STATE OF WASHINGTON
DEPARTMENT OF ECOLOGY

September 1, 2020

Re: SE-20-00003

Thank you for providing the Department of Ecology (Ecology) the opportunity to review the mitigated determination of non-significance for the construction of two storage ponds to hold septage, proposed by Brown & Jackson, Inc. The Department of Ecology's (Ecology) Shorelands and Environmental Assistance (SEA) Program has reviewed the documents and provides the following comments:

SHEET NO. C1.2
201834

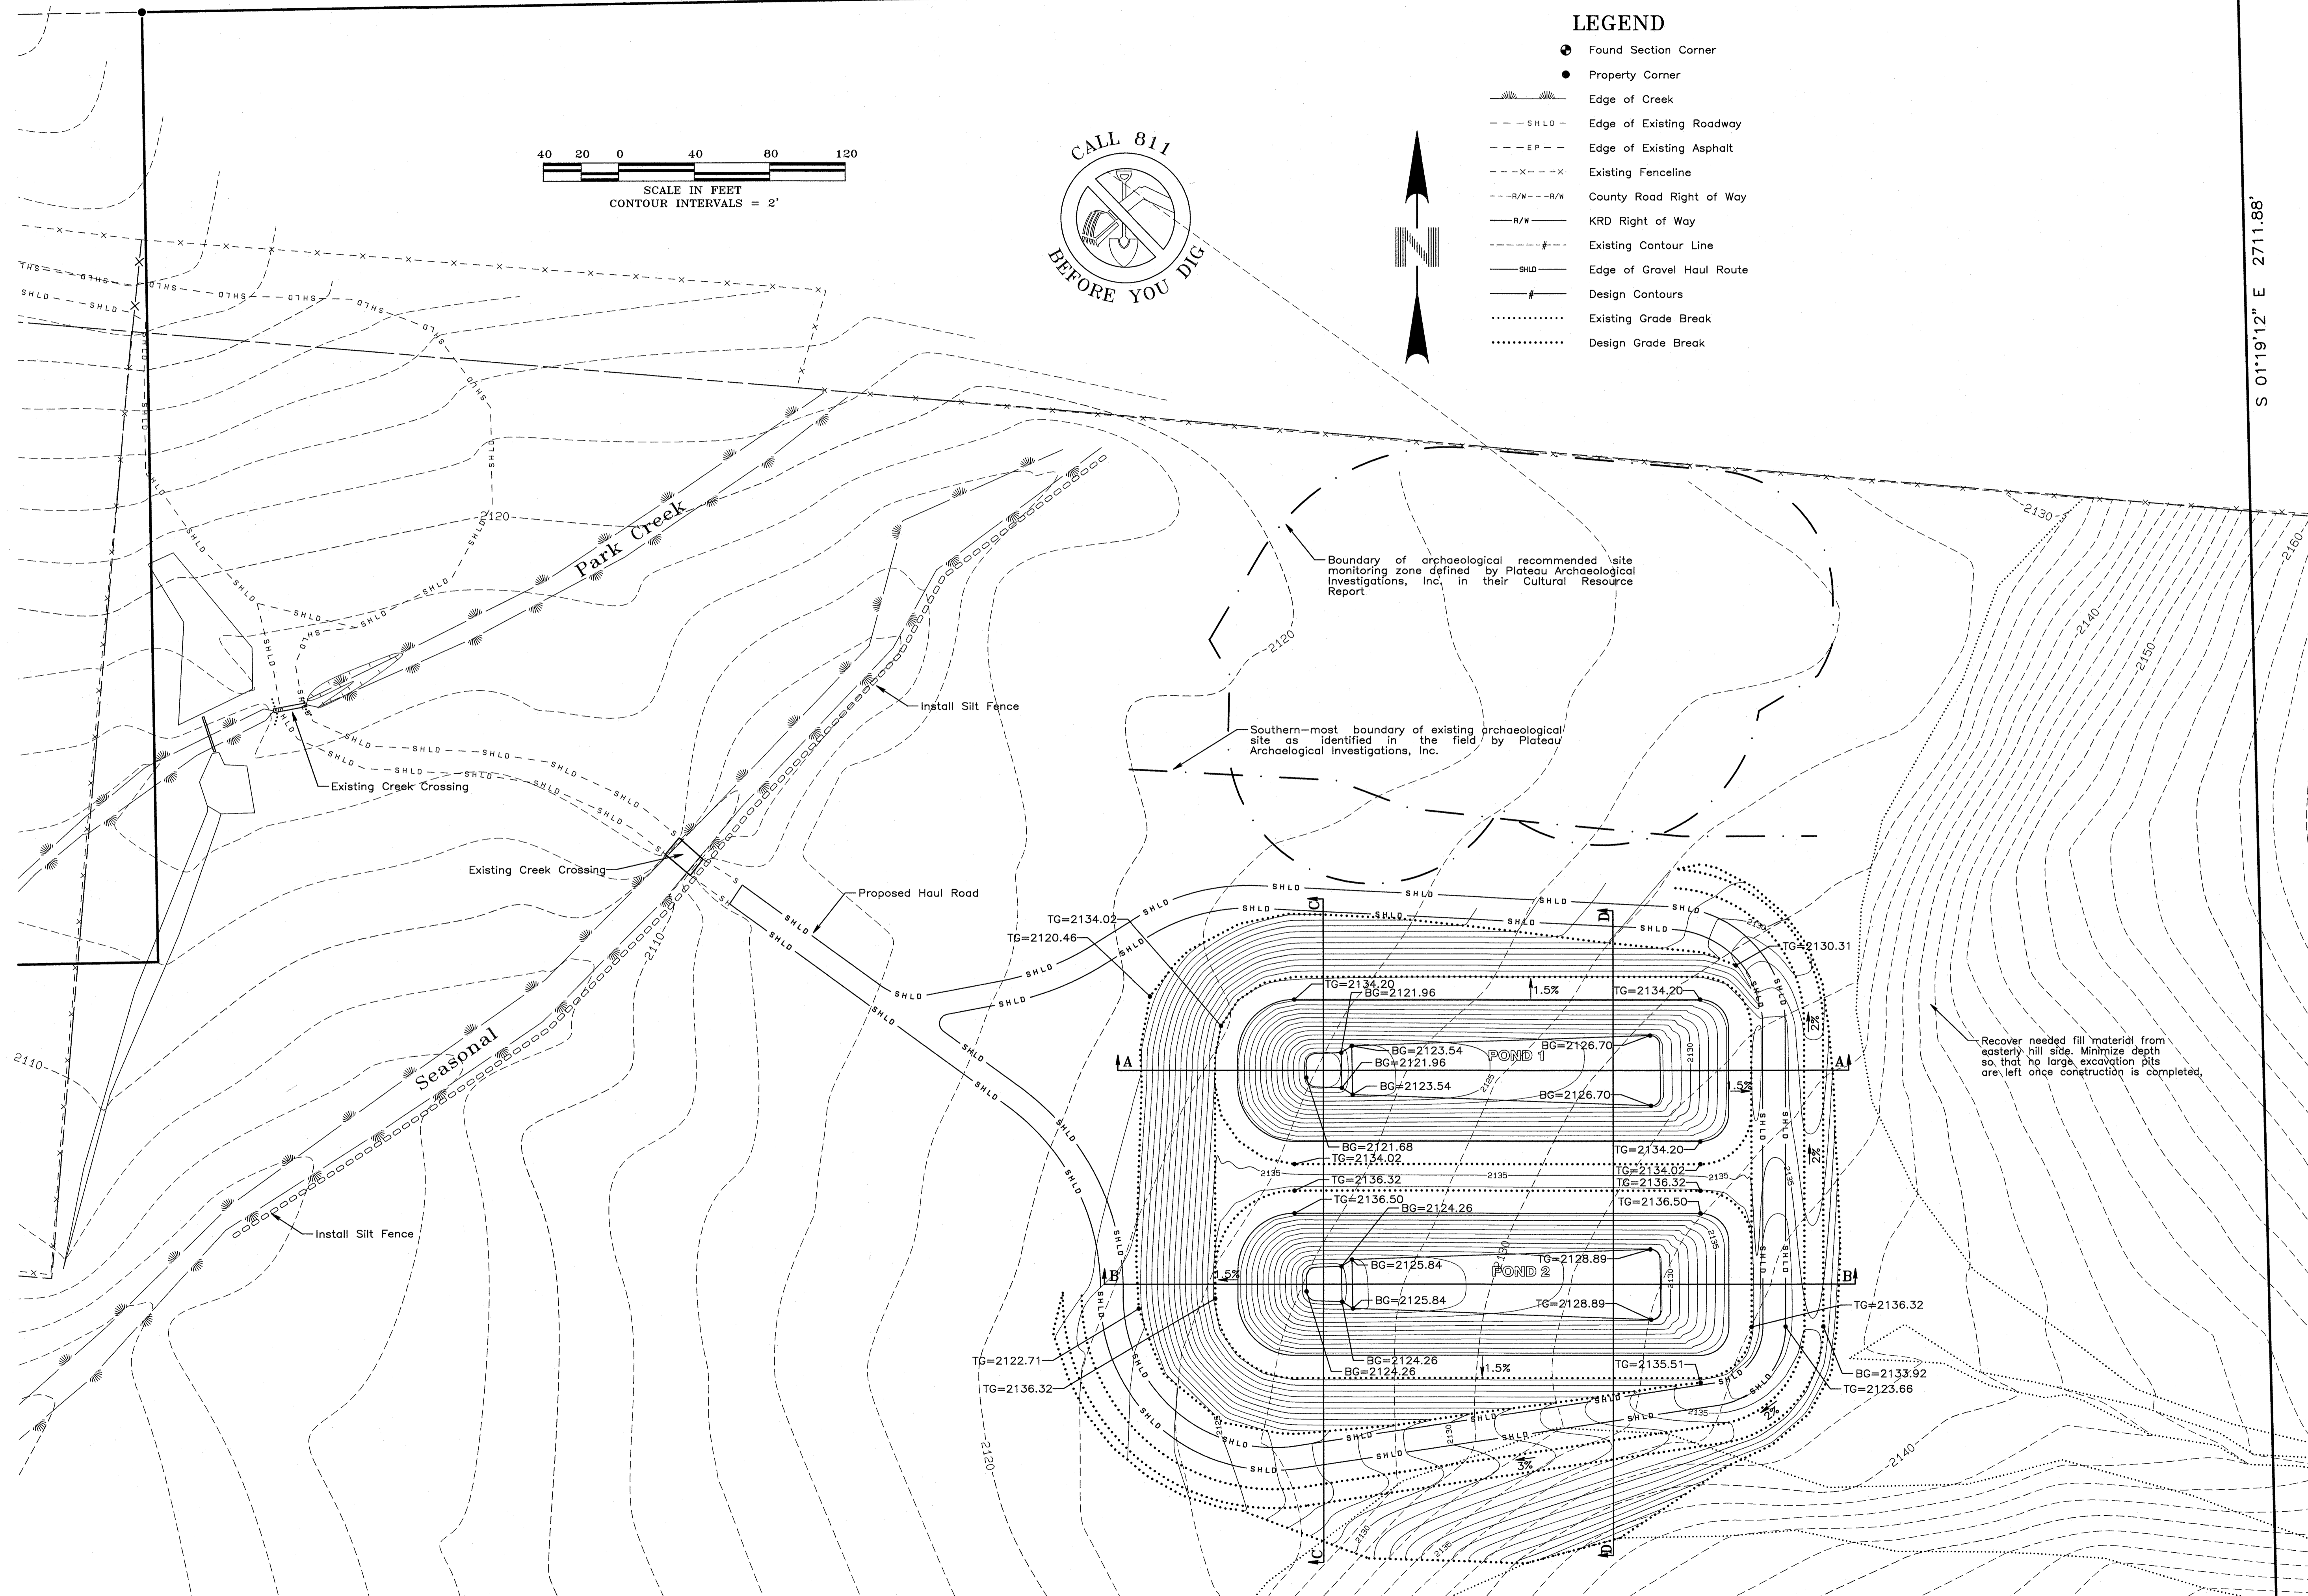
The collective information suggests a wetland could occur within the parcel boundary at the bottom of the foothill (see Image 1 below; area outlined in white). It appears development of the parcel in this particular area, could impact potential wetland and buffer habitats.

Ecology recommends the County request a wetland investigation be conducted prior to the mitigated determination of non-significance issuance. Per Revised Code of Washington (RCW) 90.48.030, the Department of Ecology has authority to control and prevent pollution of waters of the State. Therefore, Ecology has the ability to request a copy of the wetland delineation conducted on the site to prevent the pollution of state waters.
